Development Control
Ribbles Valley Borough Council

Re: Planning Application 18/0341

Address: The Brows Farm Brows Barn Higher Road Longridge PR3 2YX

Description: Erection of log cabins and camping pods on agricultural land and formation of new access and track to service them.

Drawing Title
PROPOSED SITE PLAN

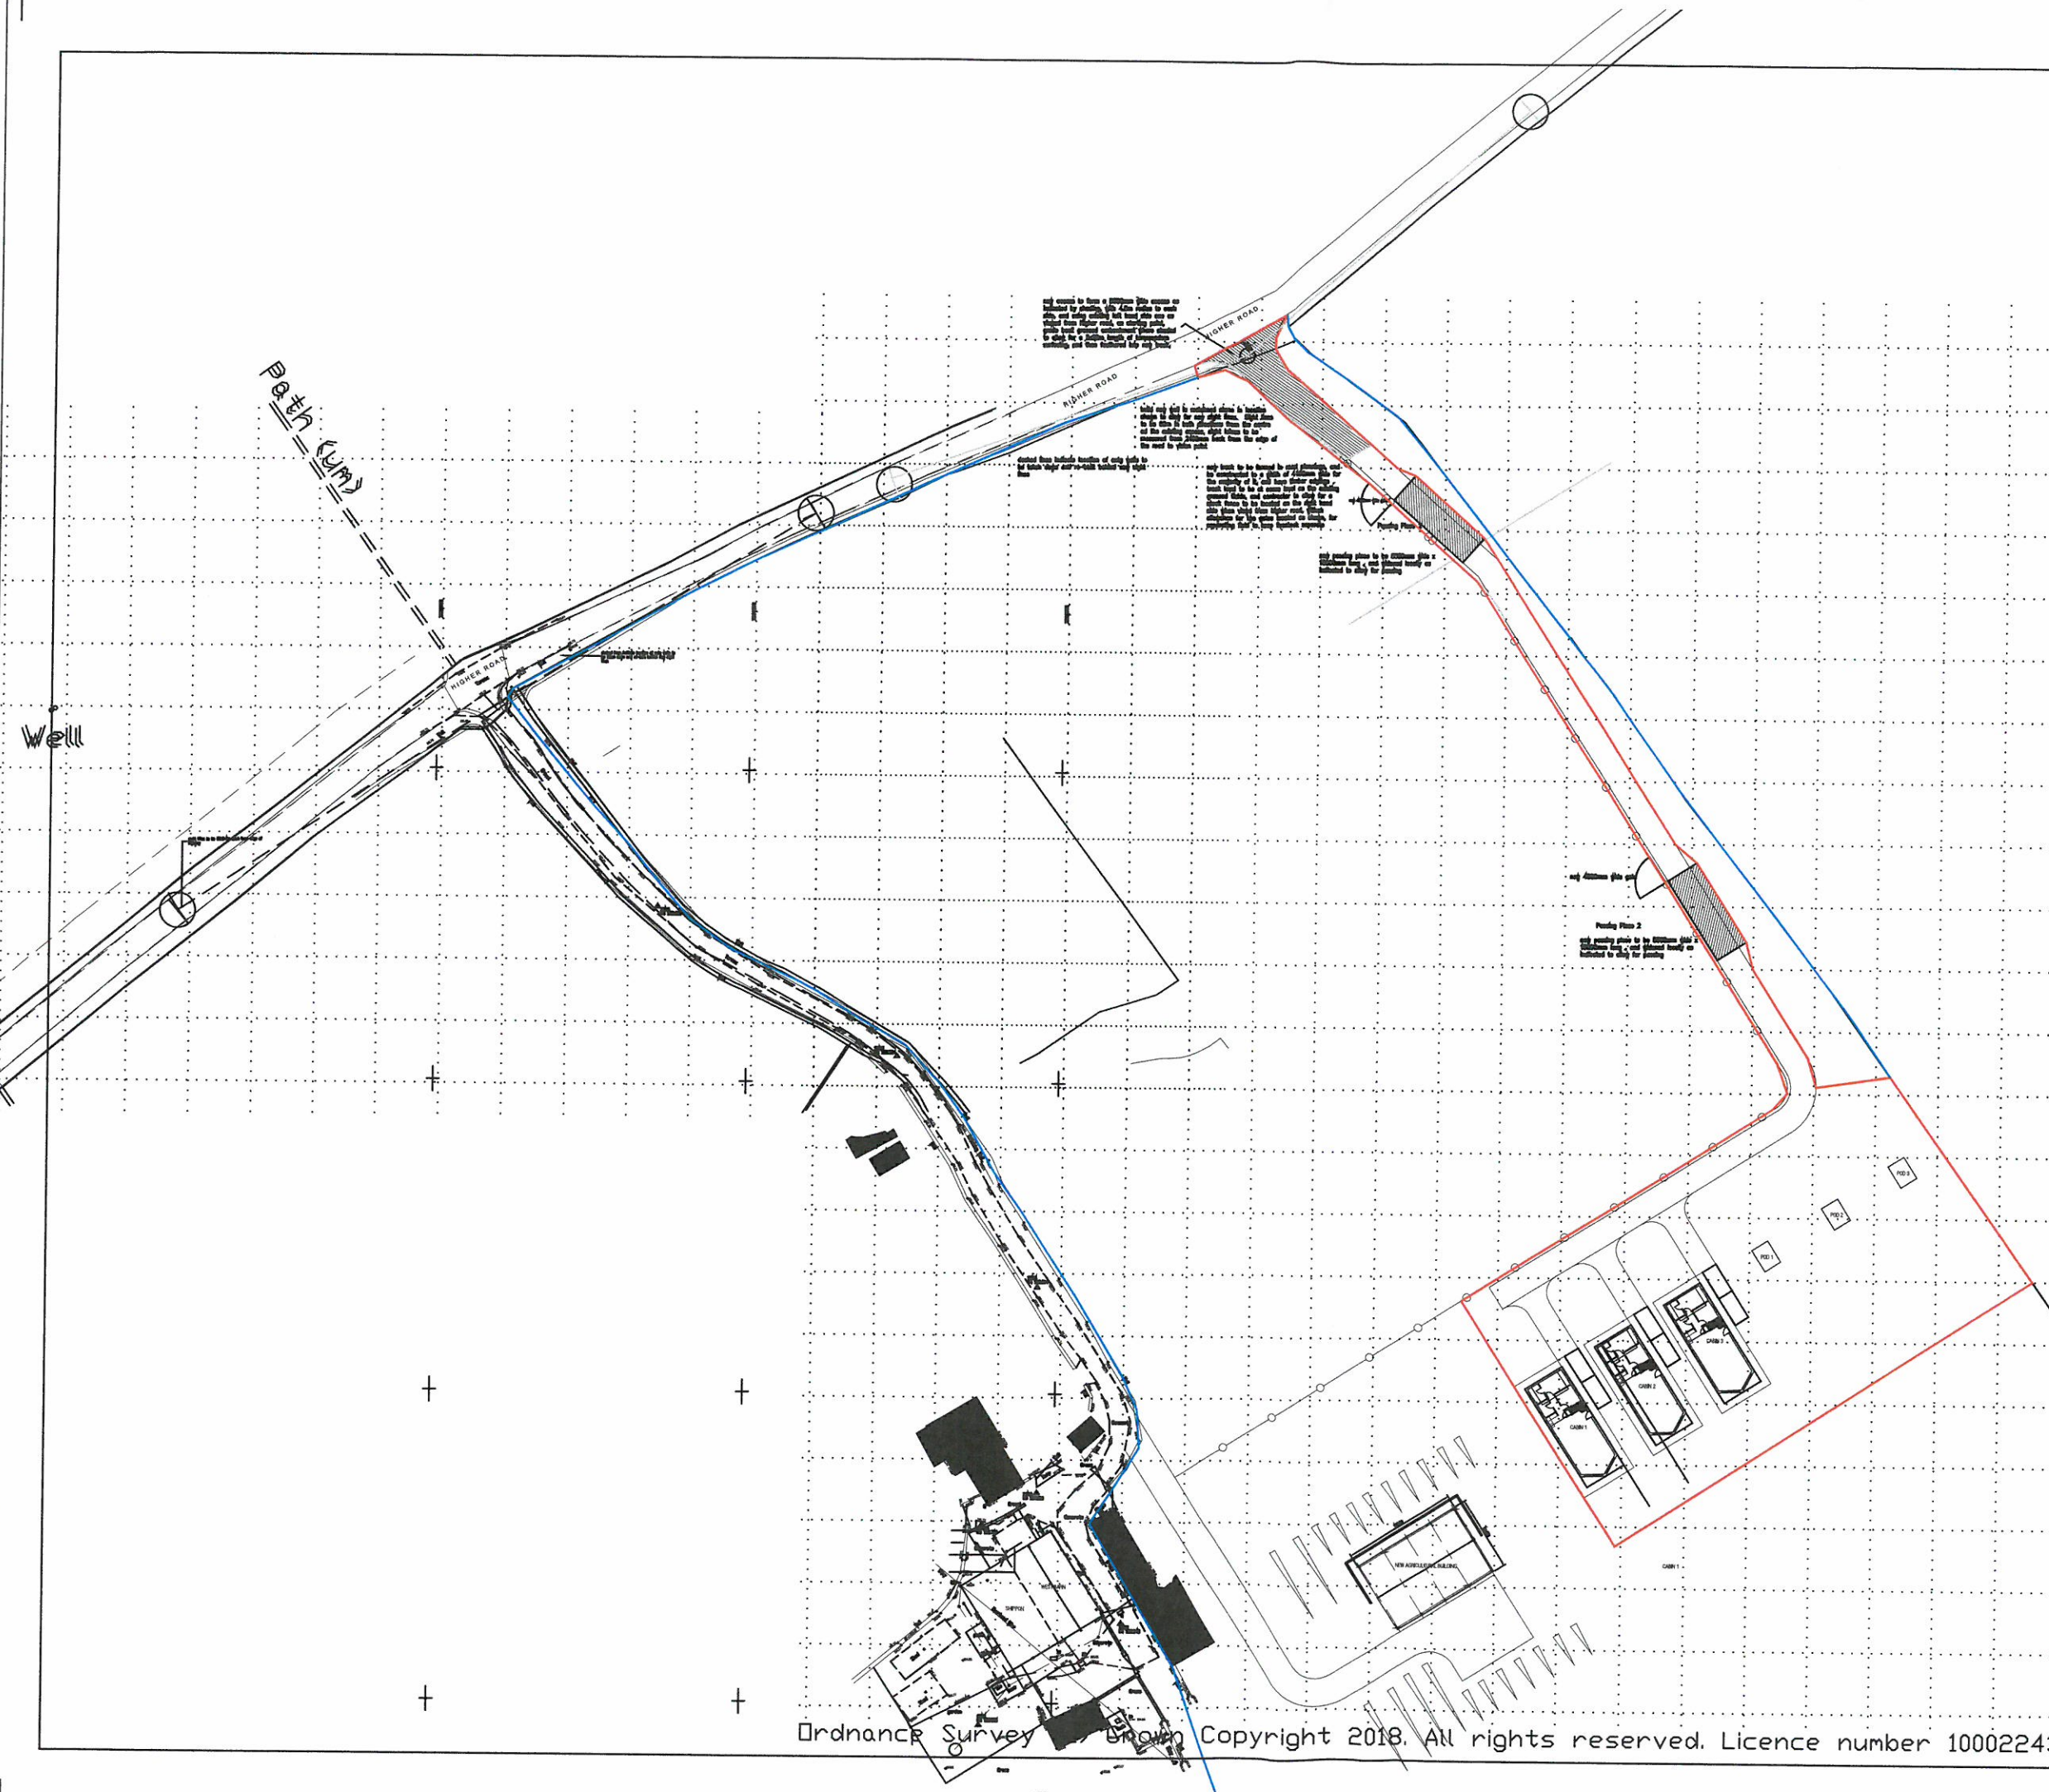
In order to pursue the application we would look for further information, including information regarding the suitability of the access from Higher Road. There is a concern that two vehicles especially those drawn trailers or caravans would not be able to enter the site whilst a second is waiting to exit a swept path analysis of this conflict should be undertaken. This should be carried out using a reasonable size of car and caravan such as a Ford Mondeo and a caravan that give a total length of 12m.

If it is not possible for a car and caravan to enter the site whilst one is waiting then adequate provision to enable the vehicles to pass at the site entrance should be made.

Whilst the plans provided show parking provision for the log cabins it is unclear where these are to be provided to support the camping pods, these will need to be provided adjacent to the pods.
